Ref: 20C-11-0070-GCO-268448-0

RE: Acoustic Comments – Response to Atkins Acoustics letter (43.6673.L2:GA/DT/2013)

Following our meeting of 24th April at Botany Bay Council and discussions regarding Atkins Acoustics comments on the acoustic report, we hereby provide our response to the points raised in the meeting.

Existing Thursday morning
peak hour traffic flows

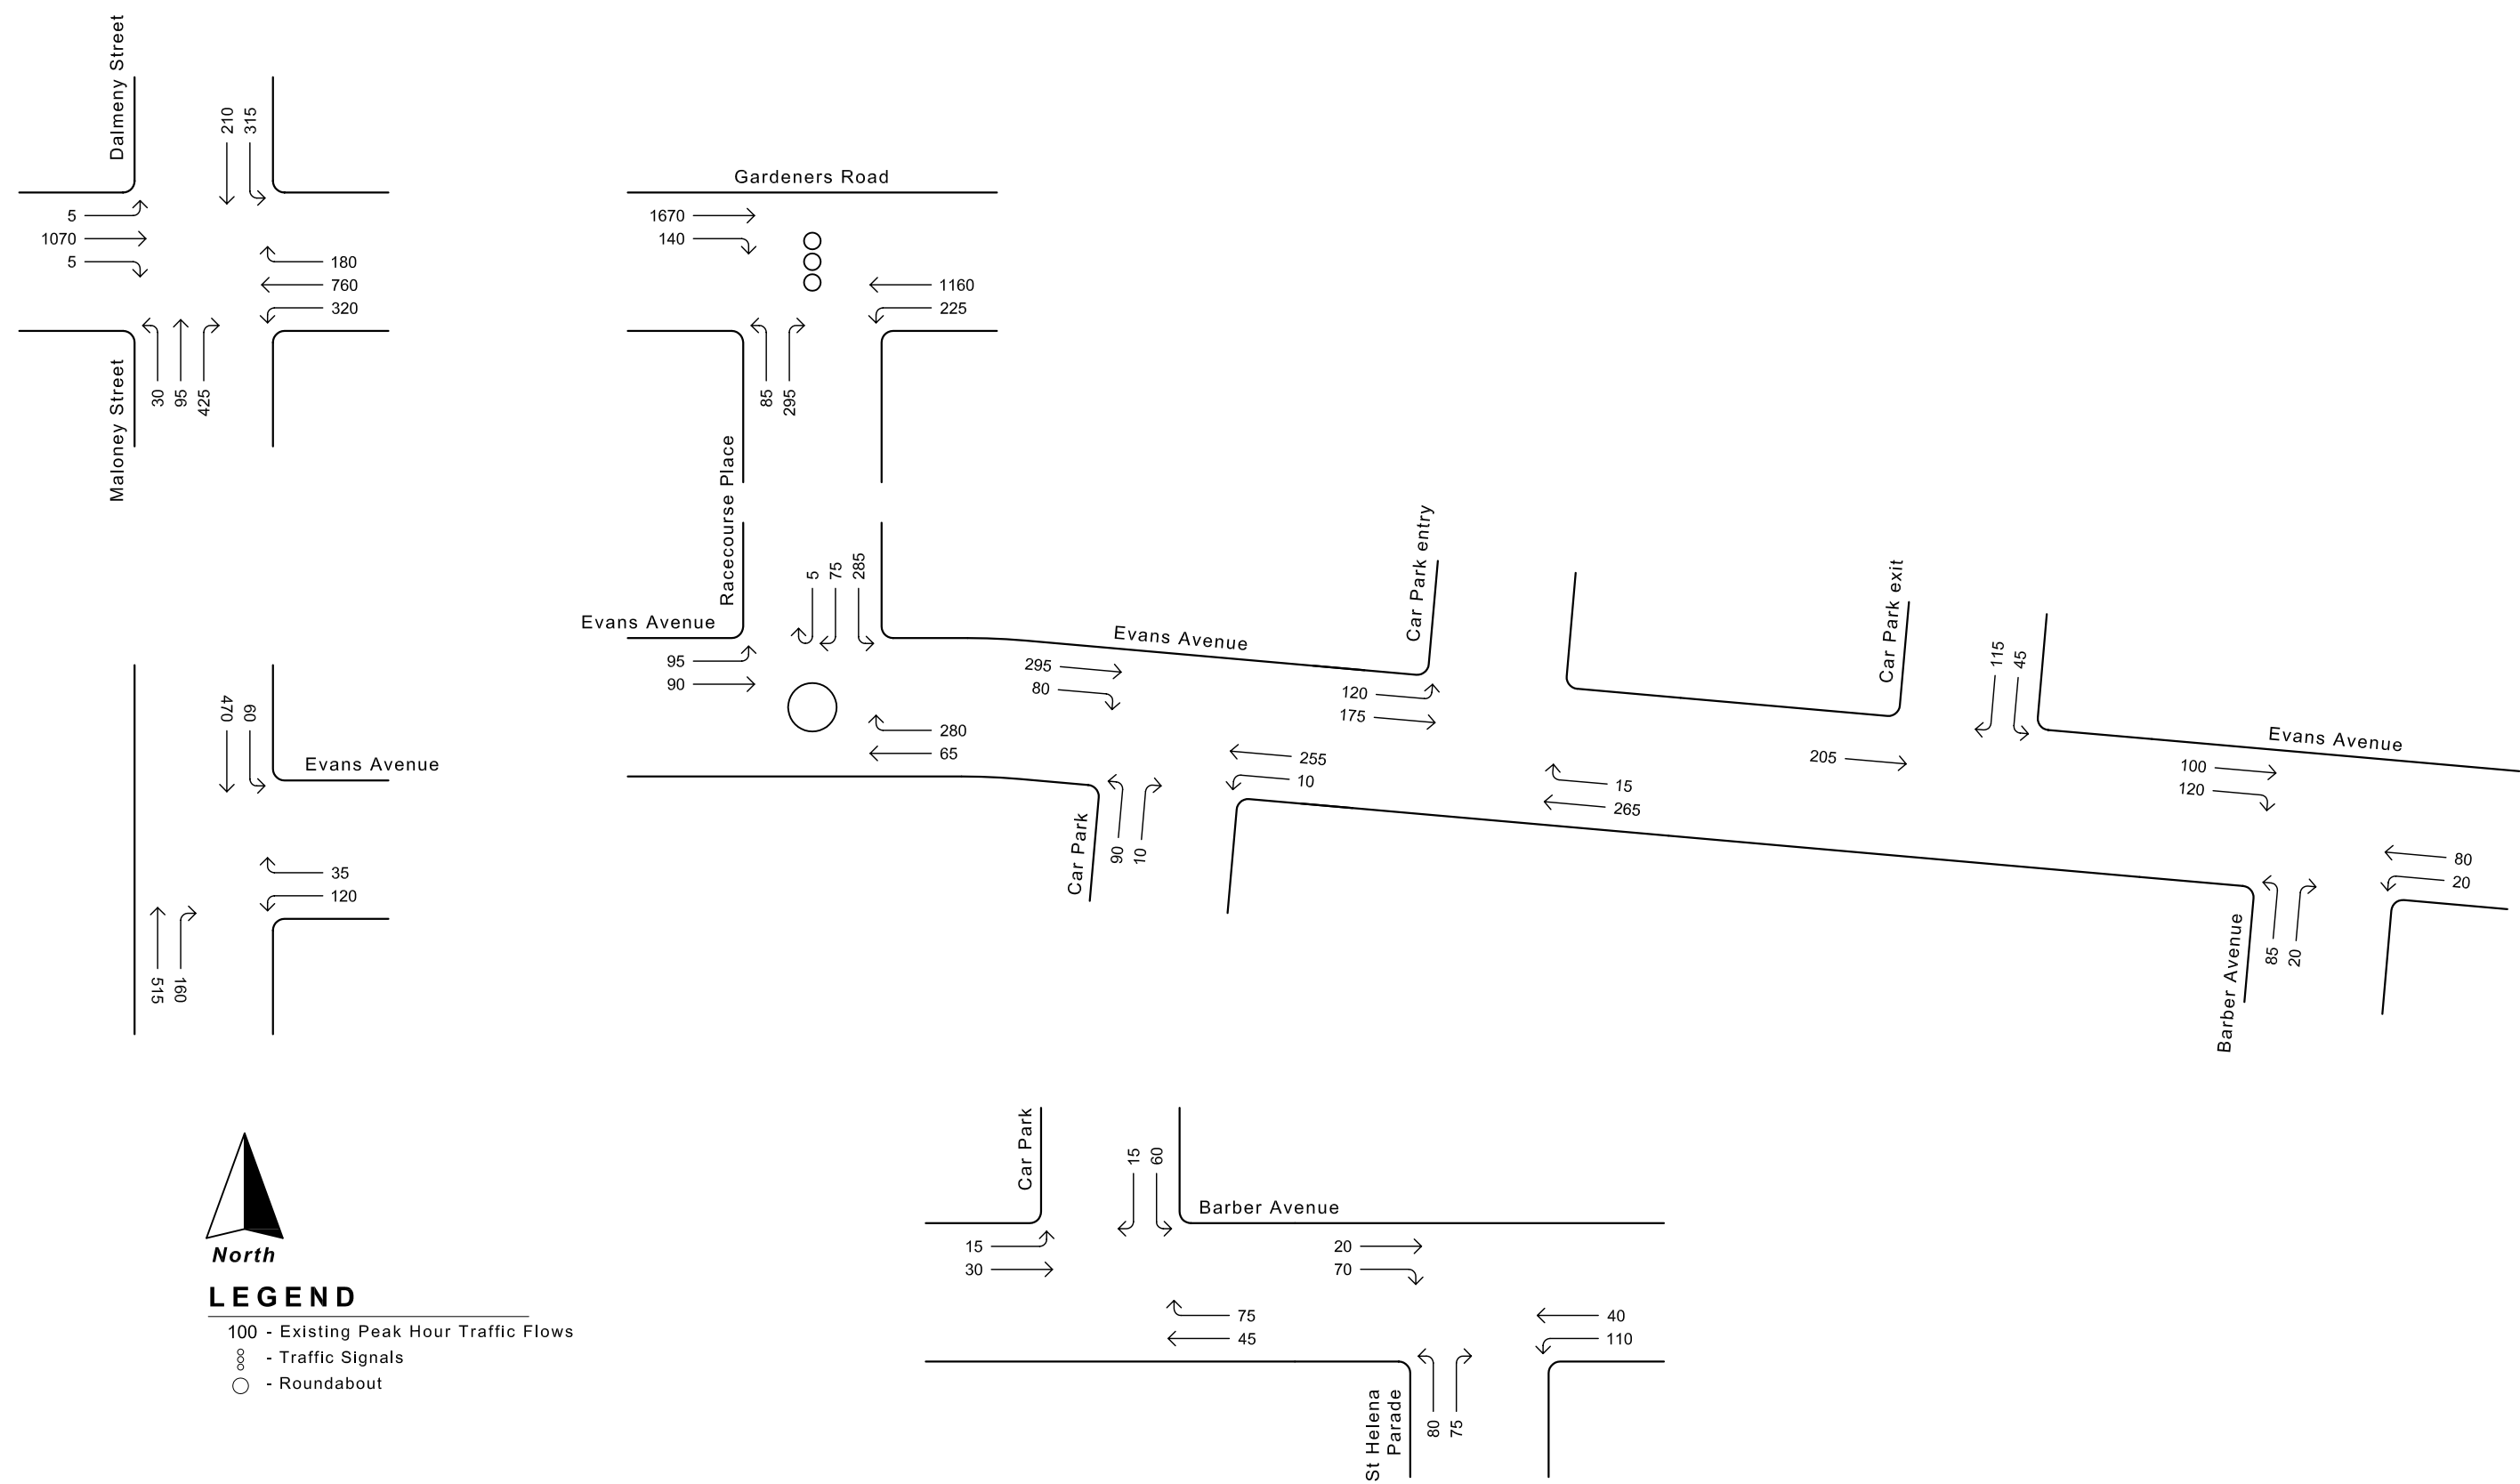
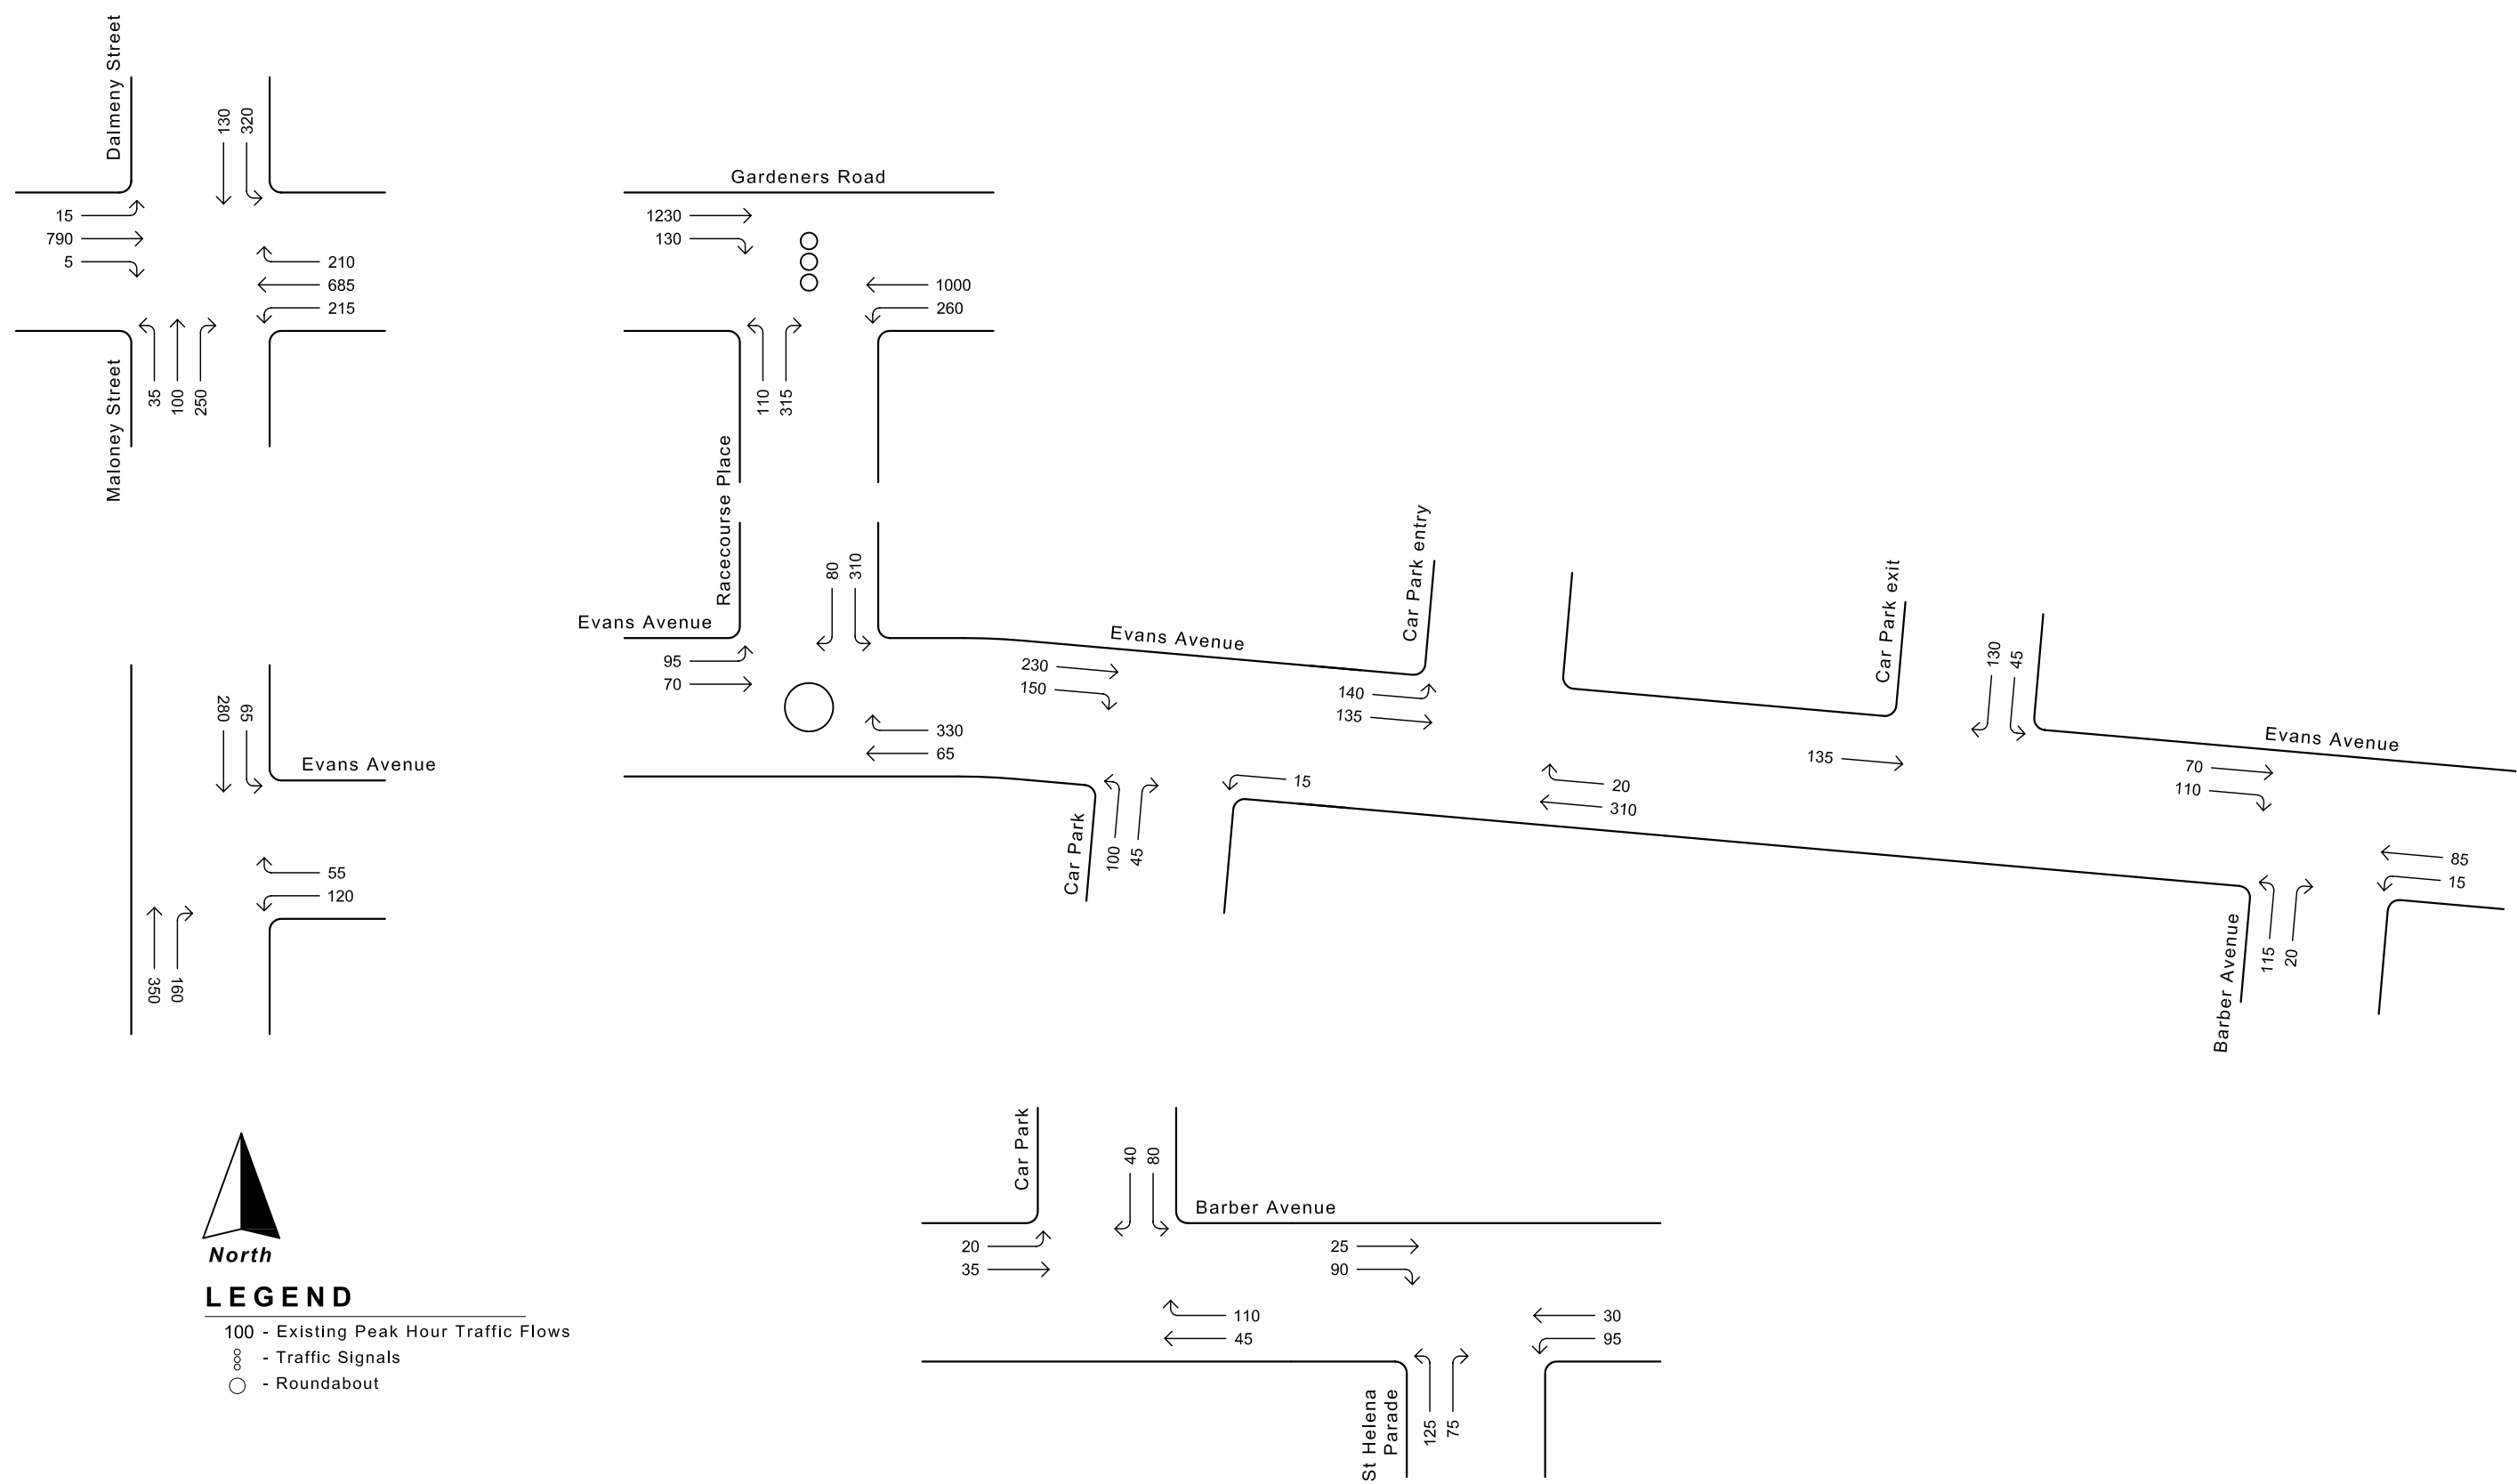
The noise level measurements presented in the acoustic report indicate that the existing noise levels exceed those levels recommended by the RNP. The traffic volumes presented in VIPAC Table 19 were obtained from CBHK traffic report dated April 2012 (Table 3.2), which was the only report available to us at that time.

The vehicle volumes are given for the three periods, Thursday morning, Thursday afternoon and Saturday midday (Tables 2.1 and 3.2 of the traffic report).

Generated traffic noise impacts based on the new traffic report dated July 2012 are calculated and presented below. The figures for existing traffic are for the residential and retail (including service) vehicles. The figures for the generated traffic are for residential and retail (excluding service) vehicles. The service vehicle volumes were added to the figures to calculate the cumulative noise impact.

Service vehicles primarily access the centre from Gardeners Road, via Racecourse Place. Large service vehicles access the centre from Maloney Street, via Evans and Barber Avenue. The following Table 2 and Table 3 present a summary for total generated traffic volumes and the cumulative noise impact from the generated traffic.
